TAG PEER REVIEW- HODDER BRIDGE, CLITHEROE

Issued 29 November 2021.

SITE PLAN_AS PROPOSED 1:500 @ A3

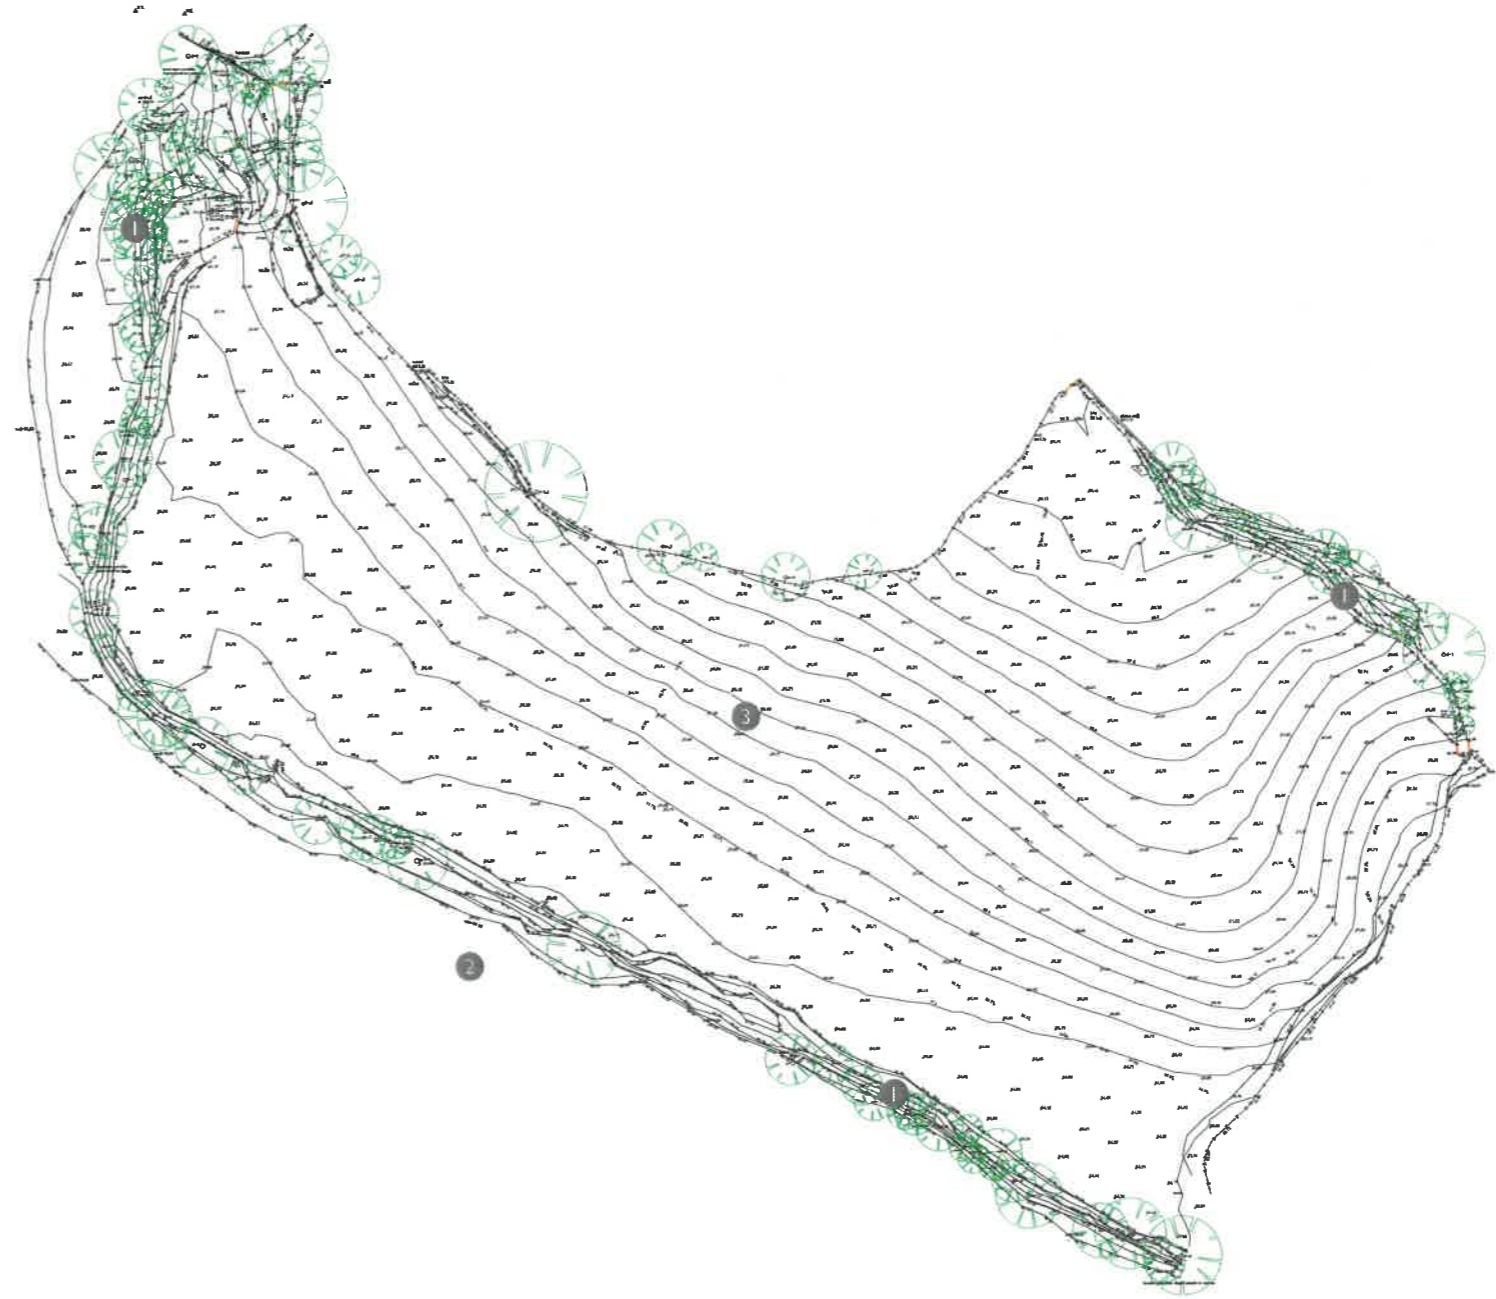
The entrance sequence from the main road is well considered. The drive is to be partly sunken into the field taking advantage of the existing contours, and gently winding to allow a sense of discovery on approaching the house. Both the digging in and curving shape suppress the effect of the drive and heighten the experience of glimpse views to the house.

Strategic trees and pinch point such as that between the central informal grove and new proposed woodland planting work to subtly frame the arrival; the true arrival being signalled by the more formal circular forecourt.

The panel was interested in what might happen with the cut and fill and how that would be managed. It was understood that all materials would be used onsite in the landscaping. Further site sections are provided to show the impact of the contouring between the as existing and as proposed.
